WEST SUSSEX COUNTY COUNCIL CONSULTATION

TO:	Arun District Council FAO: Hannah Kersley
FROM:	WSCC – Highway Authority
DATE:	30 January 2026
LOCATION:	Southern Allotments Hampton Park Littlehampton
SUBJECT:	LU/263/25/RES Approval of reserved matters (access, appearance, landscaping, layout and scale) following the approval of LU/47/11/ for Southern Allotments.
DATE OF SITE VISIT:	n/a (desktop study undertaken – site visited previously)
RECOMMENDATION:	More information required

Drawing Status	Draft		
Client	Persimmon Homes Thames Valley		
Project	Littlehampton Allotments		
Drawing Title	Vehicle Swept Path Analysis 2		
Scale	As Shown	Date	Apr 23
Drawn By	SMO	Checked By	EJD
Drawing No.	2021-6309-102		Rev.
		B

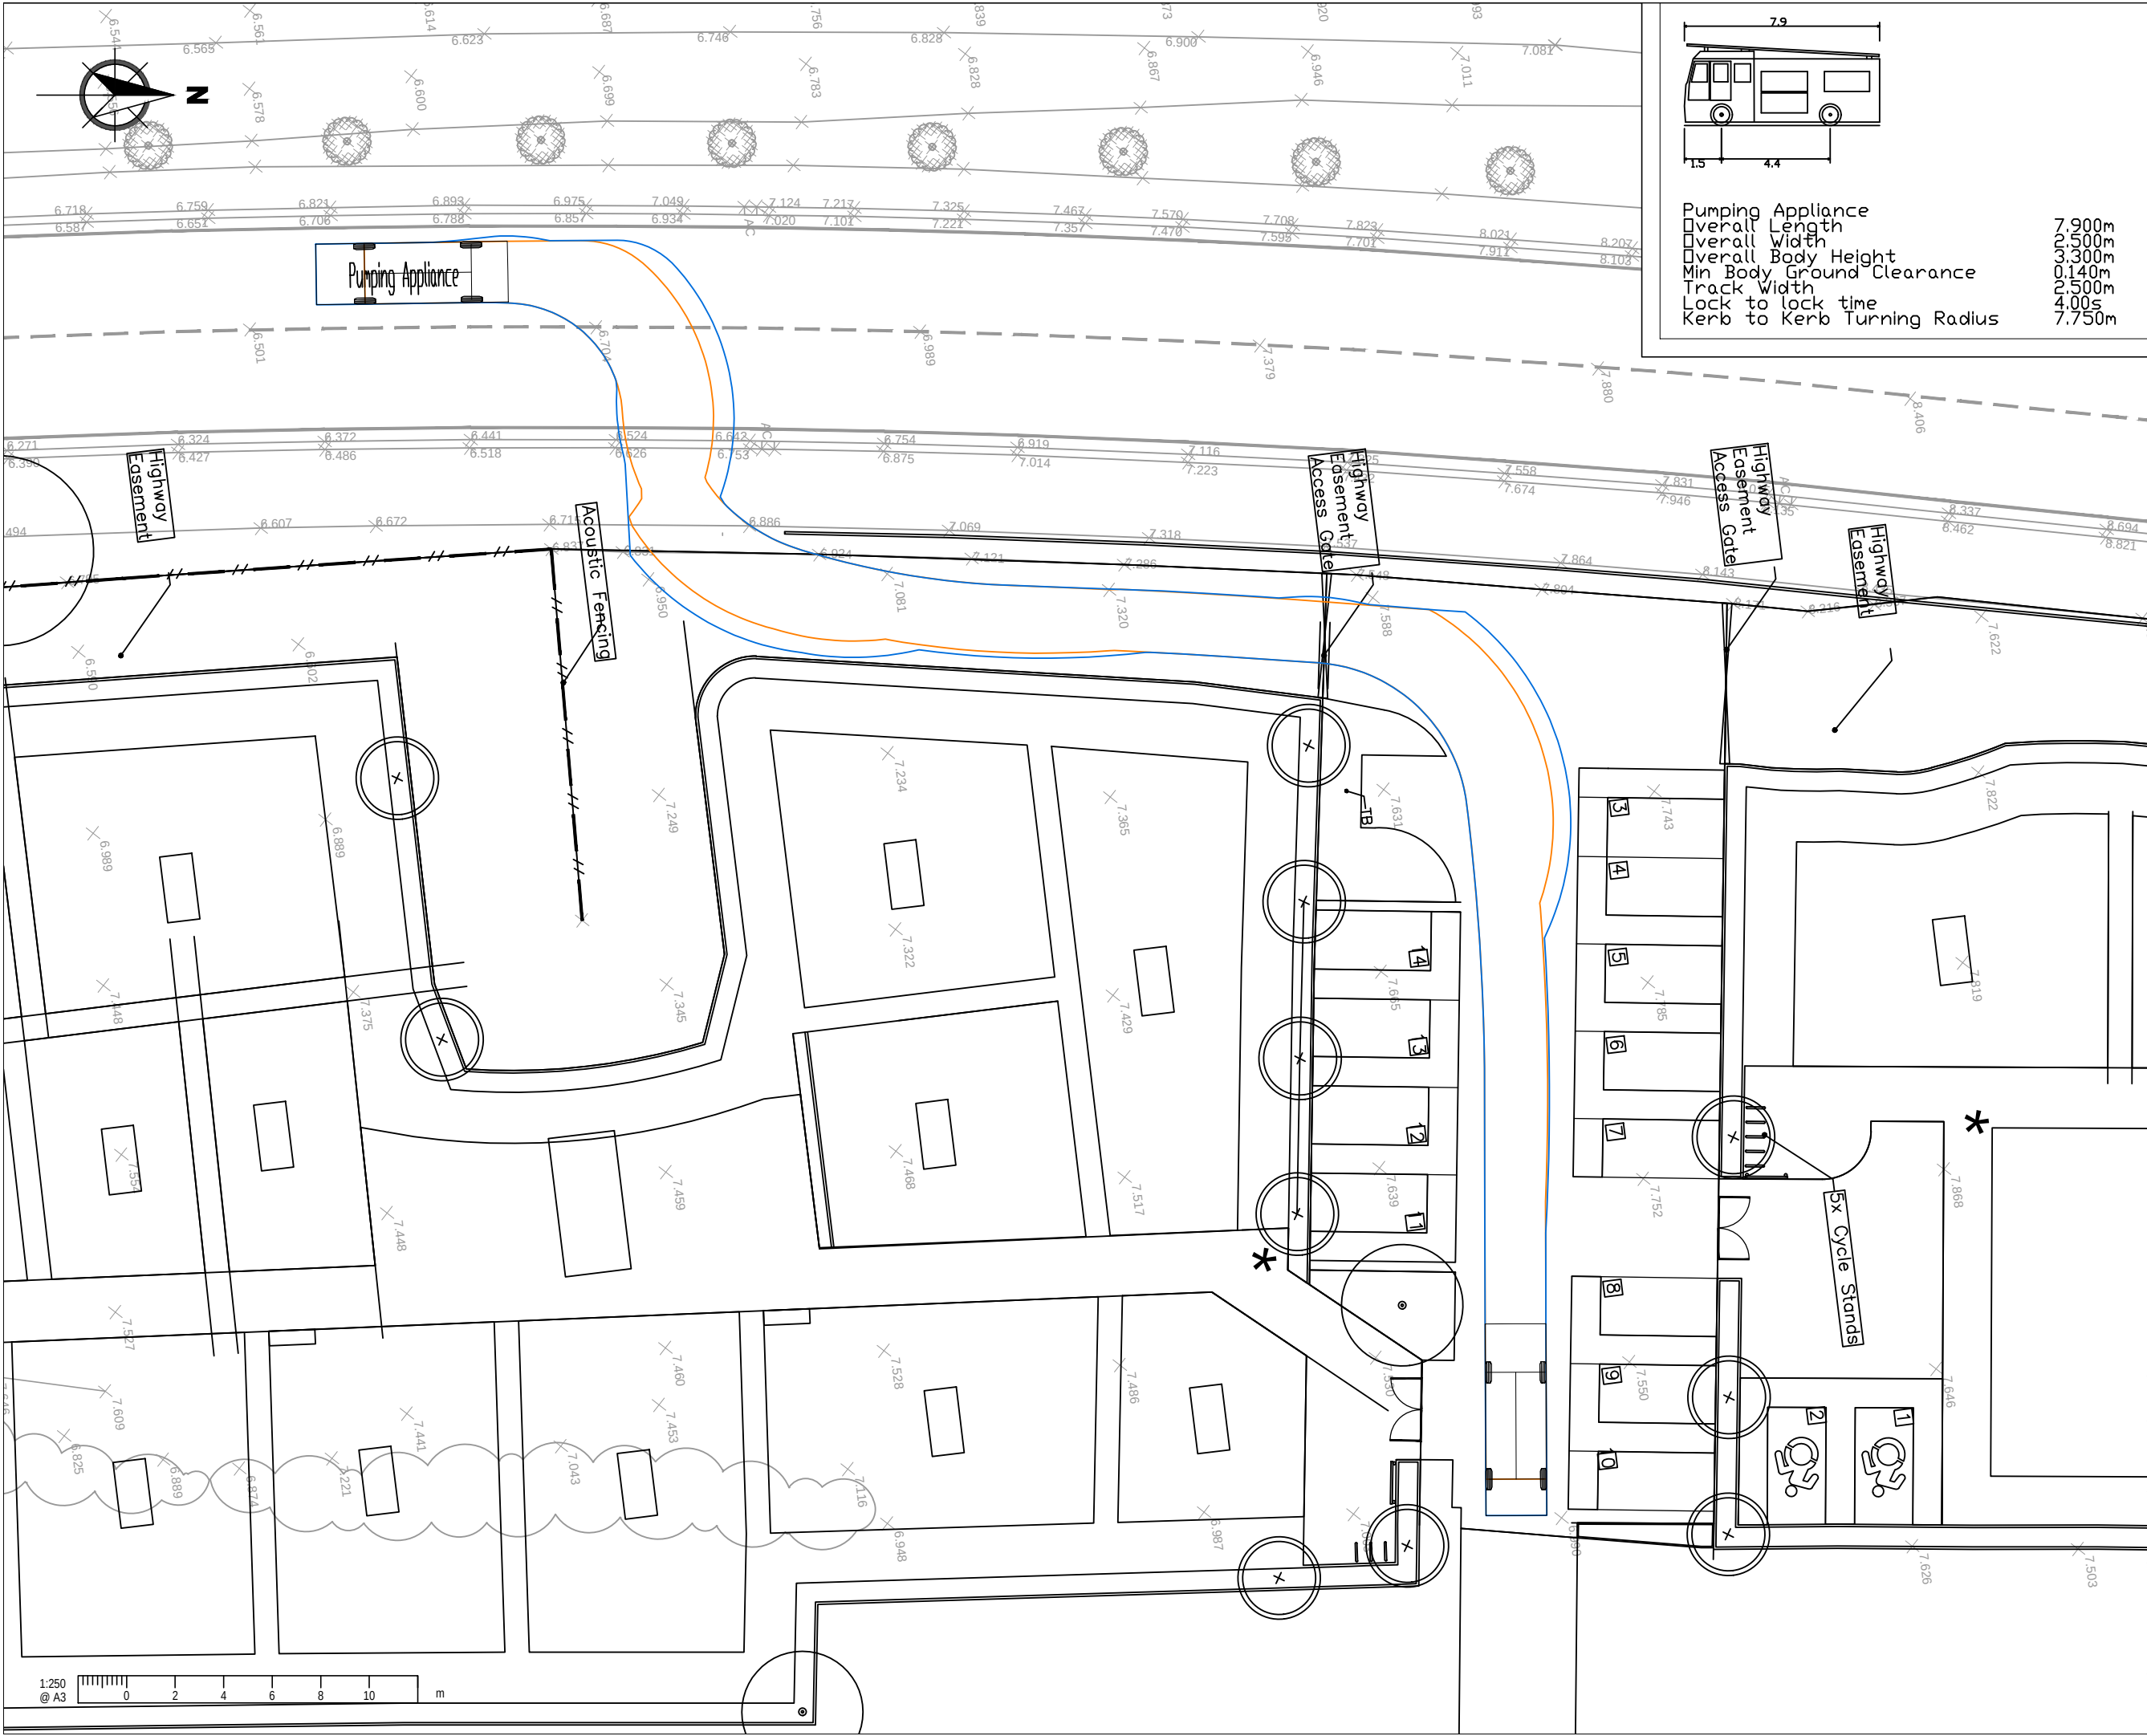
Following review of the submitted information and with specific regard to the emergency access from Nightingale Way and through the proposed allotments site, the WSCC Fire and Rescue Water and Access Officer has said that some of the more modern fire appliances are slightly longer than what has been tracked (7.6m is shown on the submitted drawings) with the Scania being 8.7m long, the control unit 9.25m and the ALP (Access Ladder Platform) being 9.5m. He has added that there does look to be other ways in from Worthing Road, admittedly all from one direction which came up previously (possibly to do with the possible closure of Toddington Lane railway crossing) and additionally after looking at the road widths, he is of the view that he thinks that the mentioned vehicles would be able to pass through if the situation required them to (which might be a combination of emergency access and existing roads).

However, given that the different lengths have been raised, the applicant is asked to provide additional tracking through the site for the vehicle lengths set out above.
